Comments for 9-1-2024 deadline

During the examination the applicant has confirmed (Doc 18.6.2 dated 14-11-2023) :-

Regulation no.5(2)(o)
 Plan No: 2.11
 Status - Final

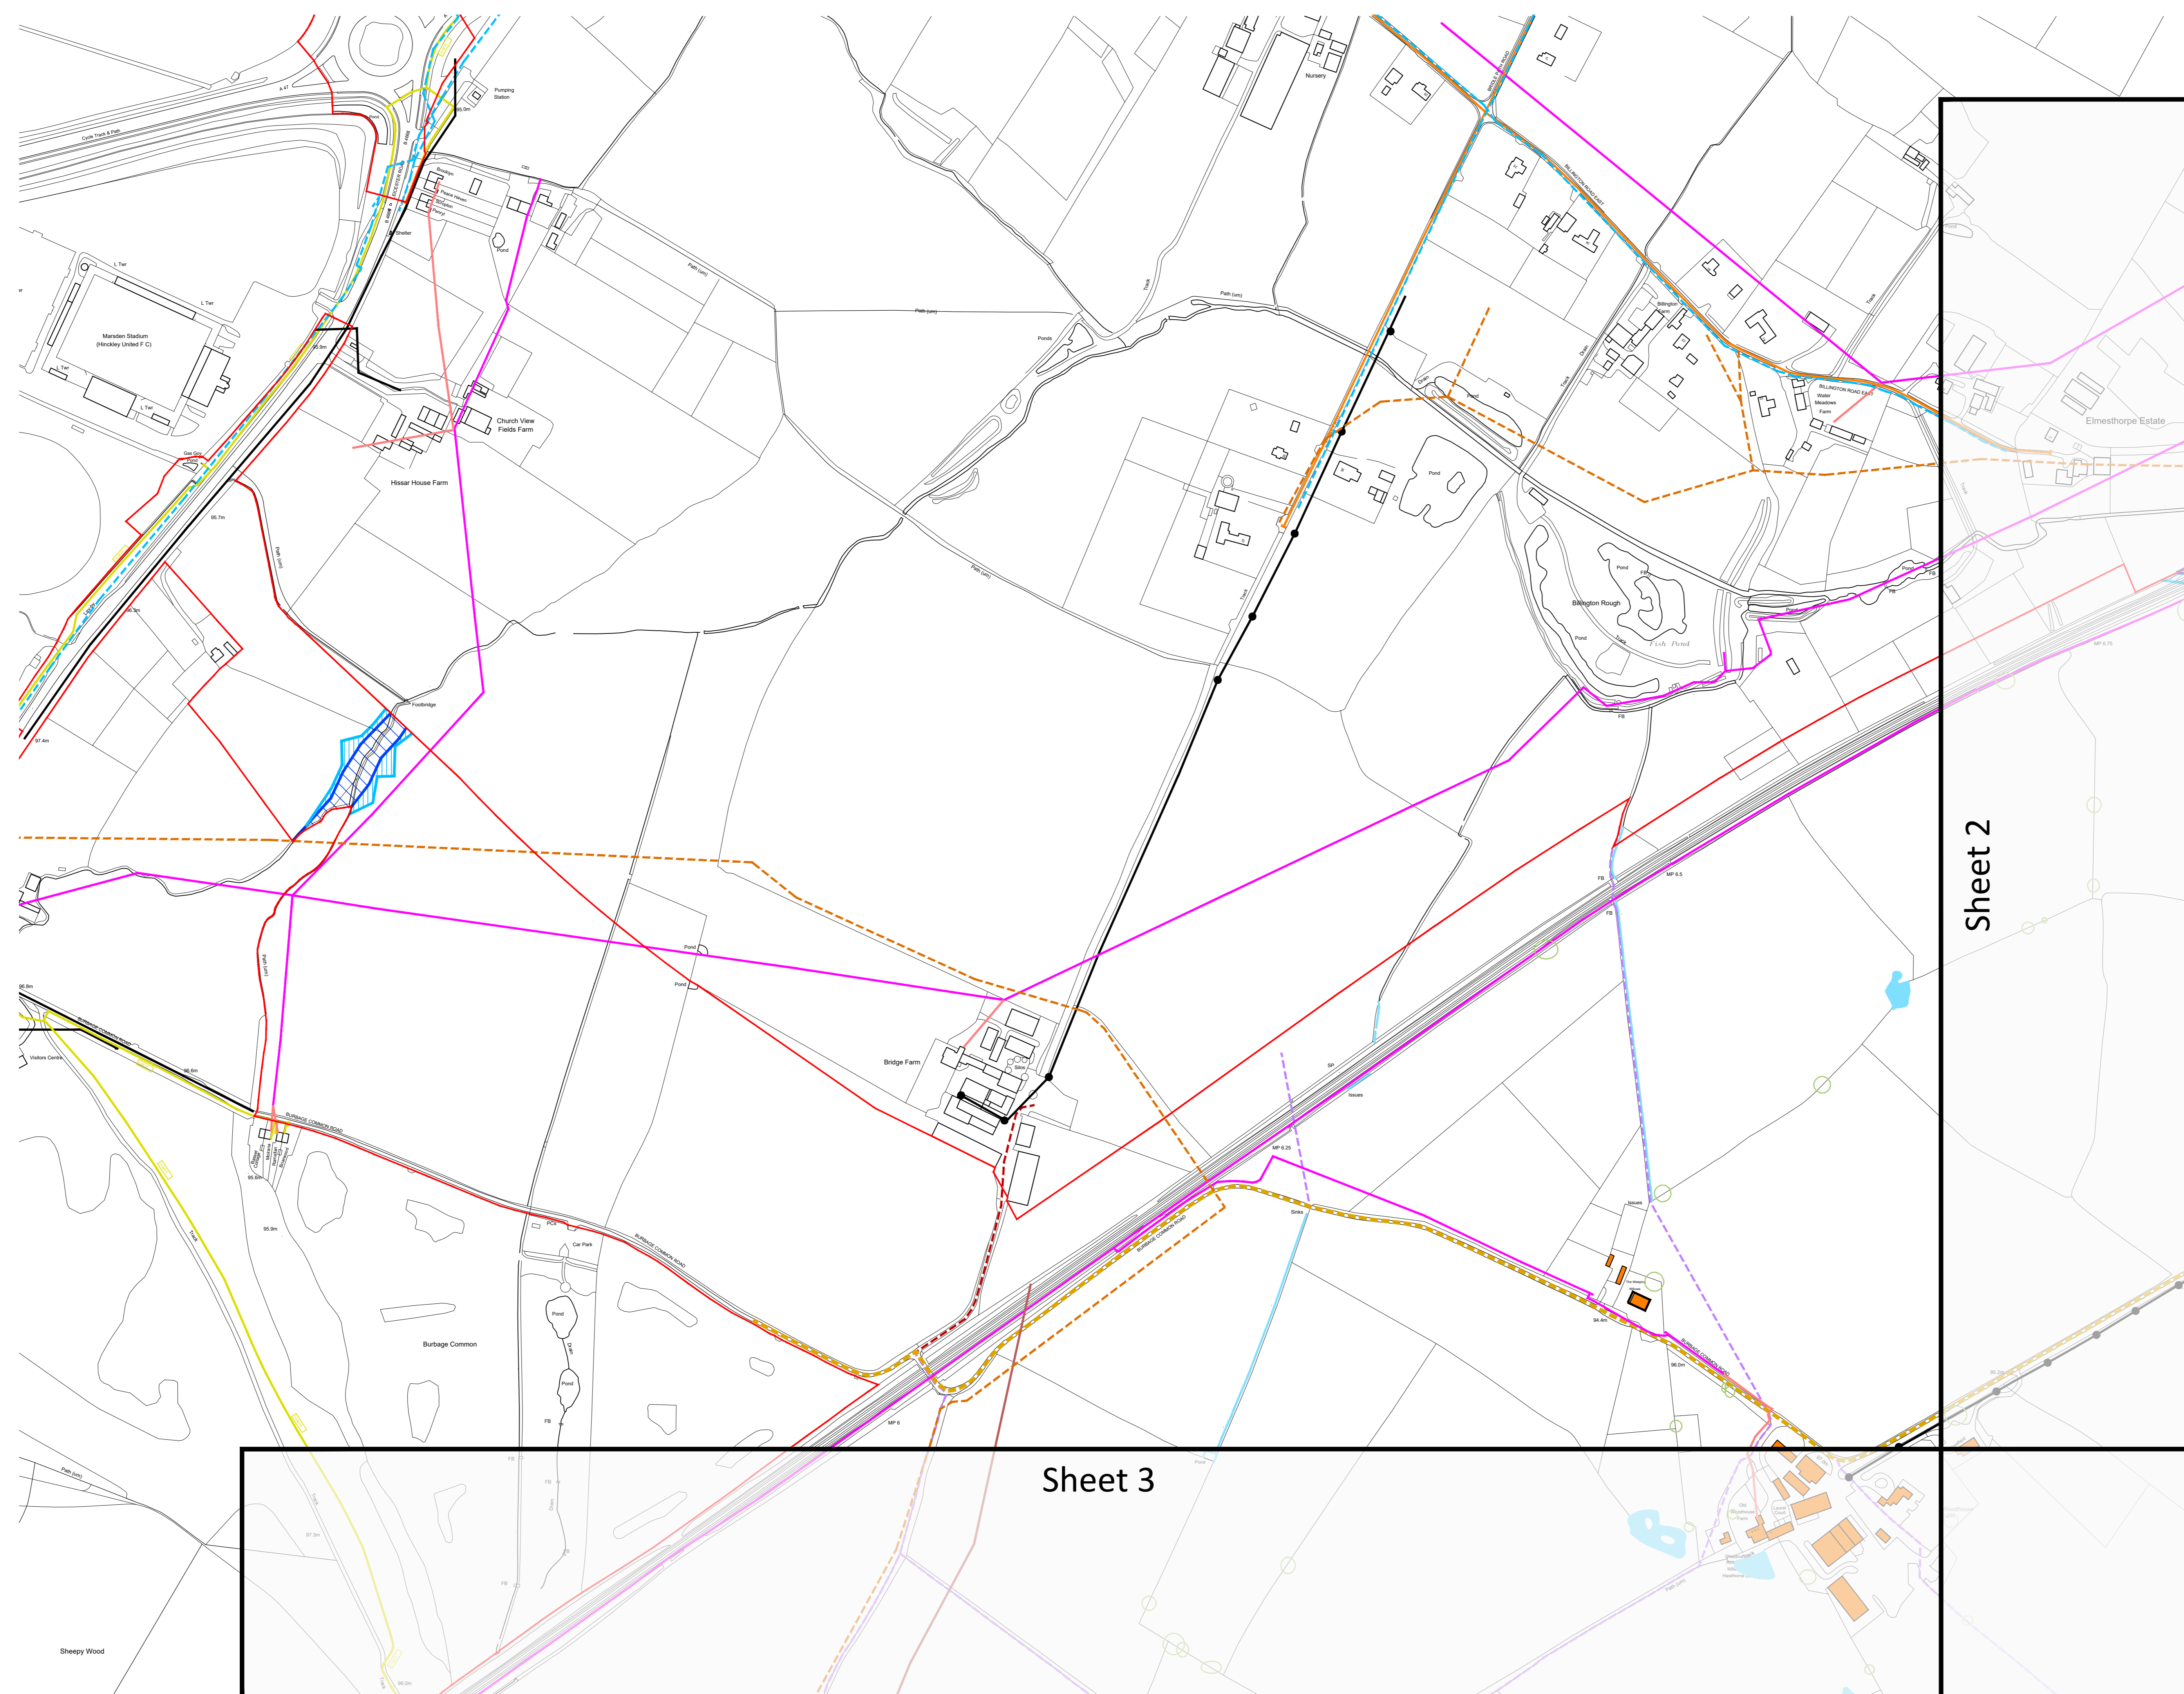
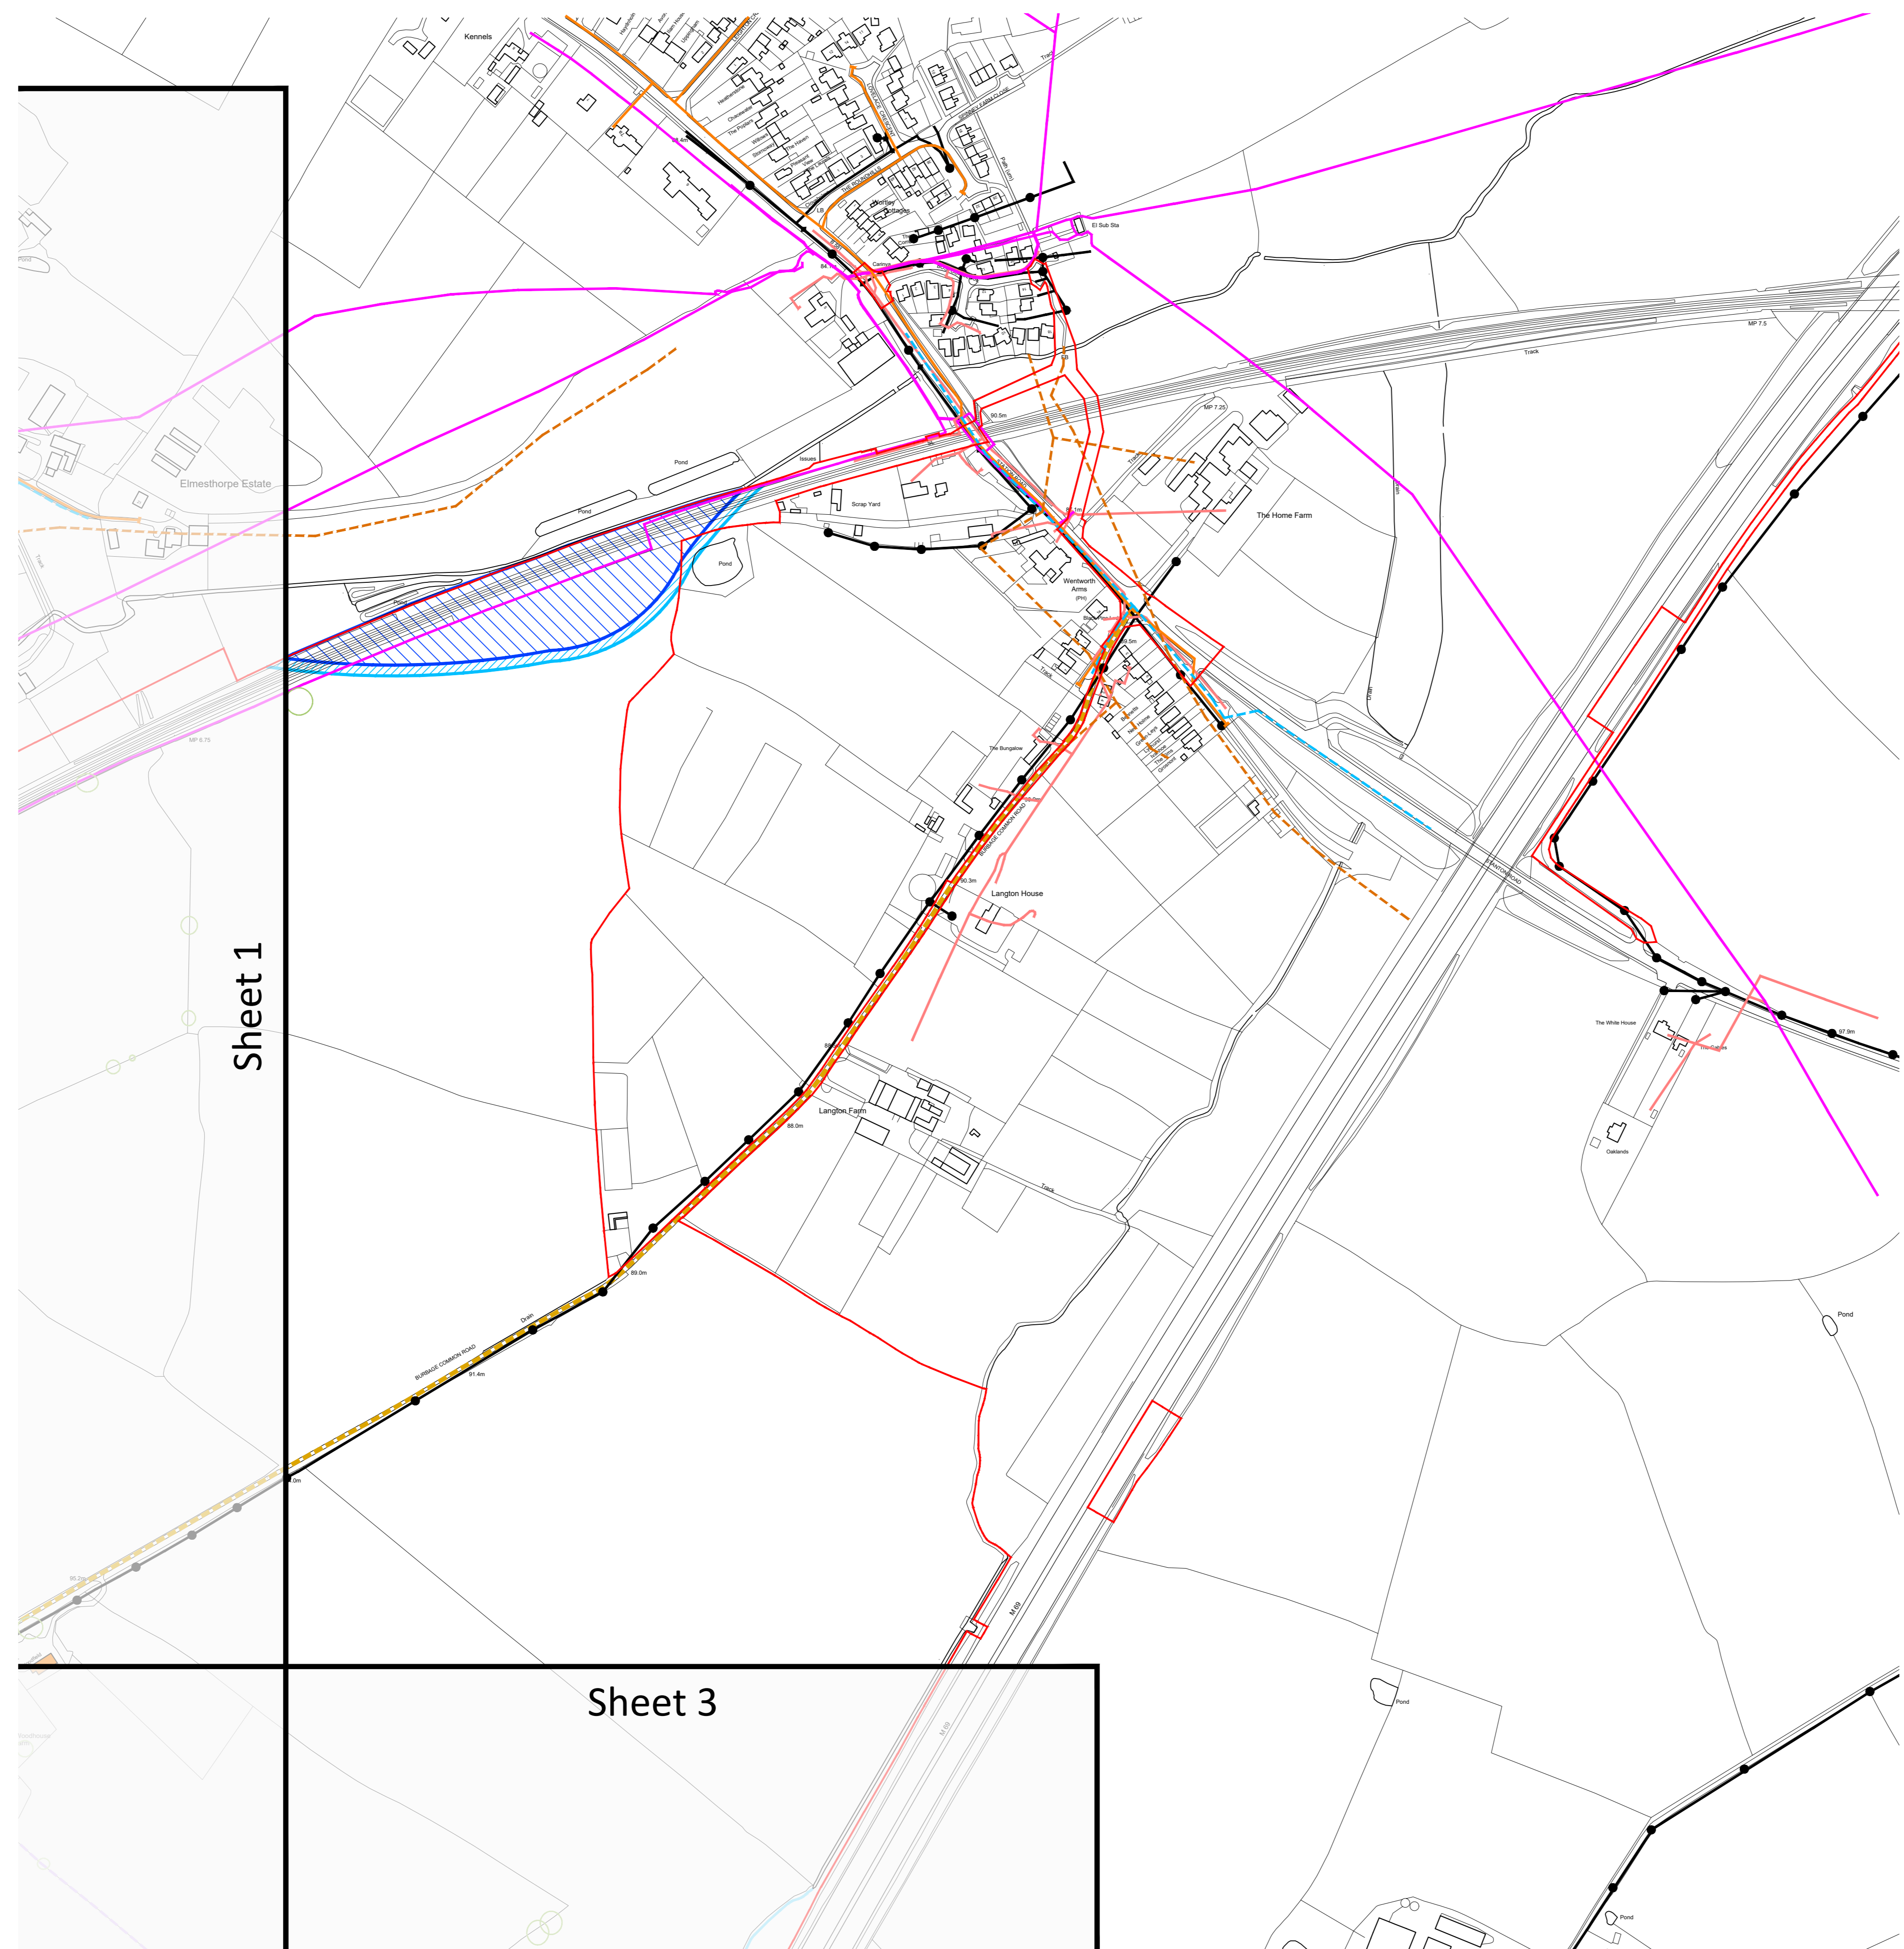
The applicant still has varying responses to the question of the 517mm pipeline (ST) going along and across the mainline railtrack within the proposed site boundaries. It is not a watermain. Away from the actual rail crossing the likely existing ground cover of 1.5 metres includes areas now planned for 6 metre excavation. I have seen no confirmation this pipeline is to be diverted before the earthworks start ?
